Erection of four terraced residential dwellings, garden/cycle storage sheds & associated car parking, utilising the existing access - This application may affect the character & appearance of The Steyne, Bognor Conservation Area & will affect the setting of a Listed Building

Former hotel tennis courts adj to The Royal Norfolk Hotel West Street Bognor Regis

Thank you for your internet representation made on 21st November 2018 which has been recorded as '**an objection**' with the comments as follows:

Drg No: **RNHB.PLAN 5**

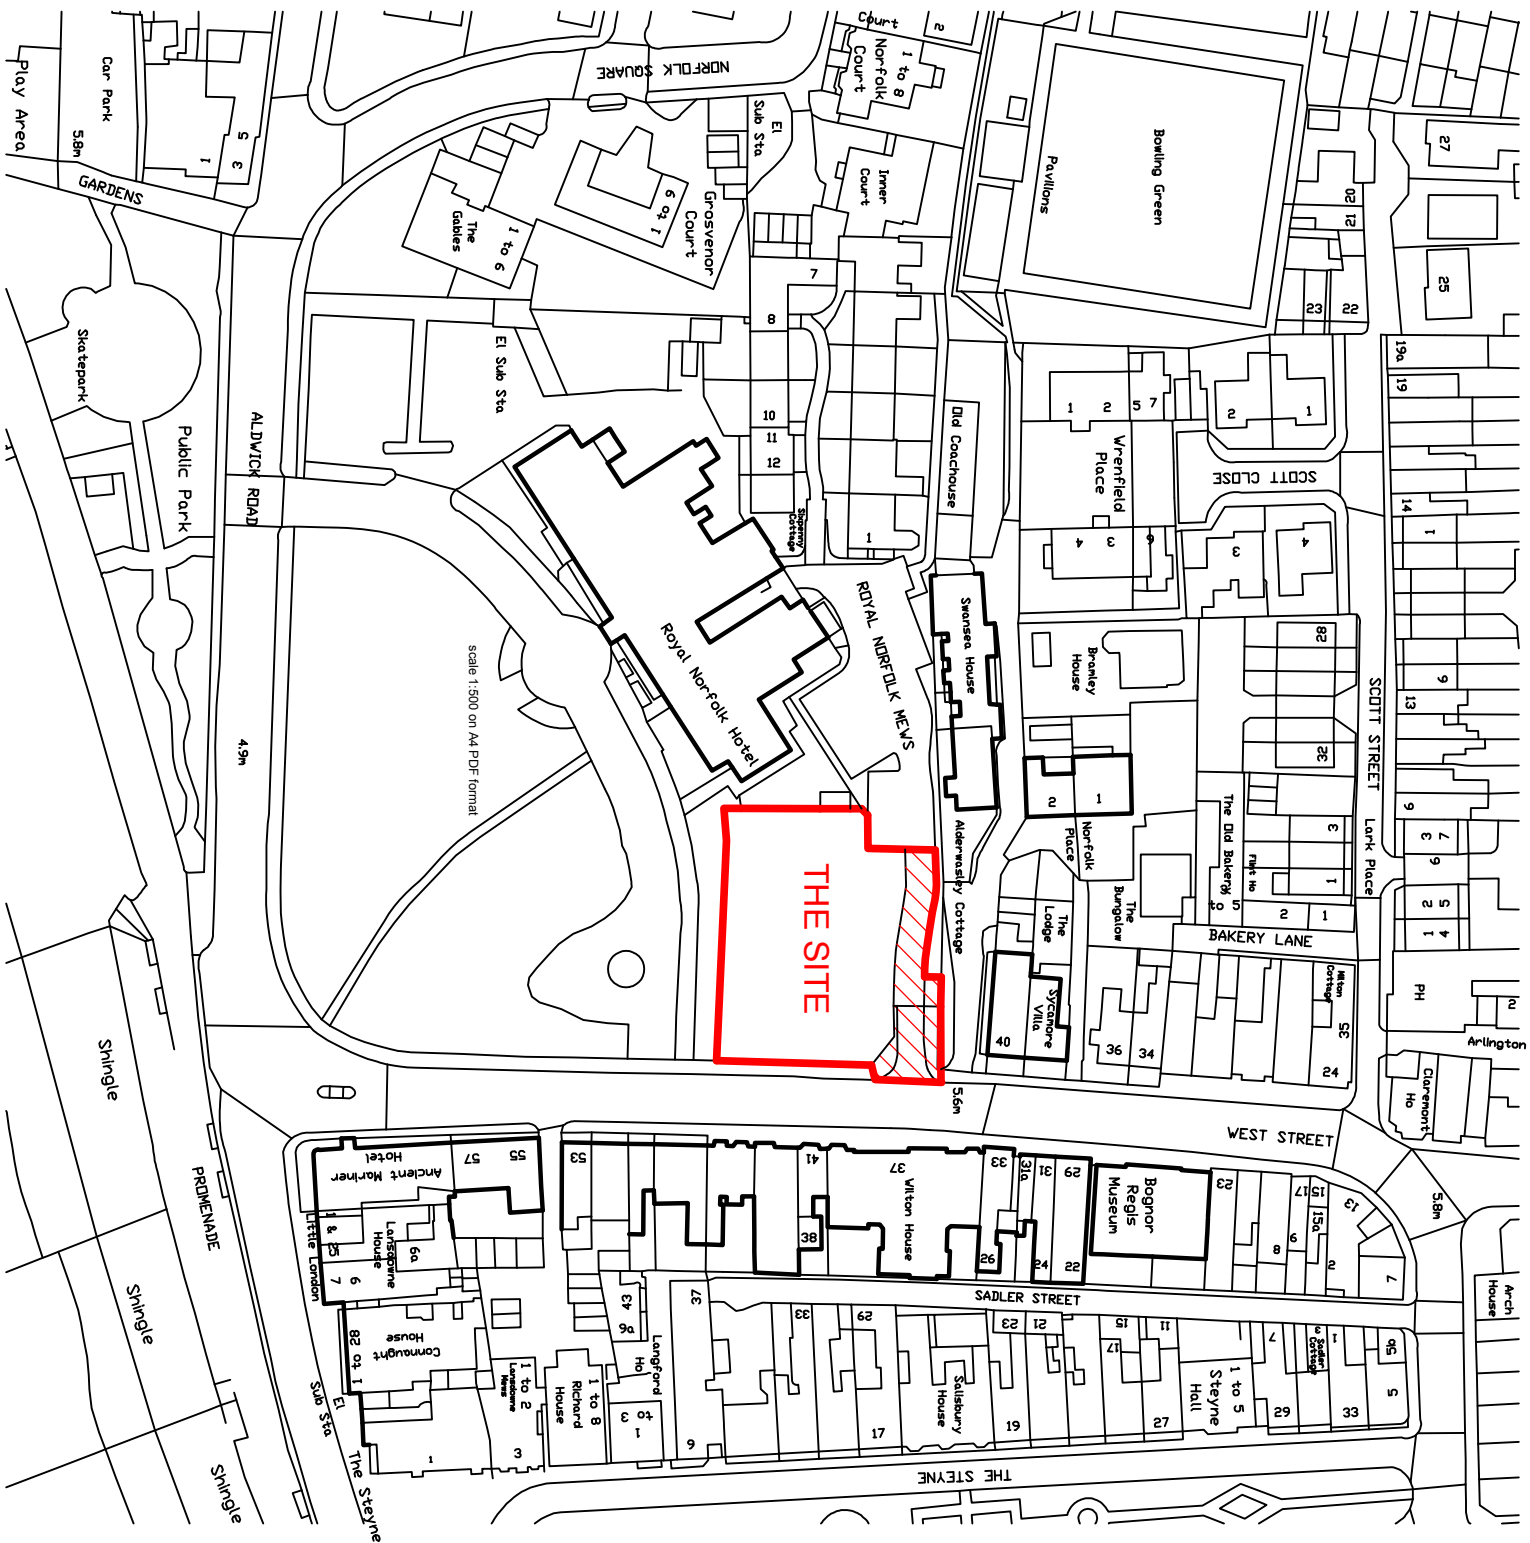
The transfer document of 8th May 2008 includes a covenant giving the transferor right of access over the entrance road through an entrance to the retained land in a position to be agreed between the transferor and the transferee. This agreement was reached and the existing wooden gates were erected and a dropped kerb installed for access to the retained land. The layout of the Royal Norfolk Mews took this into account. However, the new plans deposited with Arun DC ignore this agreed positioning and place the entrance at the western extremity of the development to the detriment of the visitor parking owned by RNMM Ltd. This is unacceptable and the plan should be adjusted to reinstate the previously agreed entrance
